**New Request for Advice – Sutherland Entertainment Centre
(SSD-10379) (Sutherland Shire)**

TAB A – TfNSW Comments – SSD 10379 EIS Sutherland Entertainment Centre

FIGURE 10: HAULAGE ROUTE FOR 20M LENGTH ARTICULATED VEHICLES

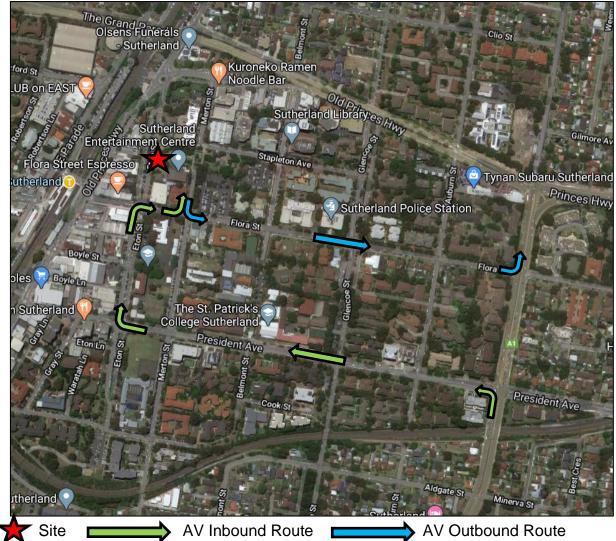
On page 84 of the TPIA, the swept path plans show an articulated vehicle (AV) turning at the intersection of Acacia Road and President Avenue. The swept path appears to travel onto the kerb and median island striking the signal post on President Avenue. Similar for the exit from Flora Street onto Acacia Road, the AV travels over the kerb while making this turn. TfNSW does not support these movements as they present unsafe and inefficient scenarios for the road network.

It is requested that the applicant be conditioned to submit swept path design plans of the longest vehicle (including garbage trucks, building maintenance vehicles and removalists) entering and exiting the subject site, as well as manoeuvrability through the site, to Council for approval, prior to issue of the first Construction Certificate.
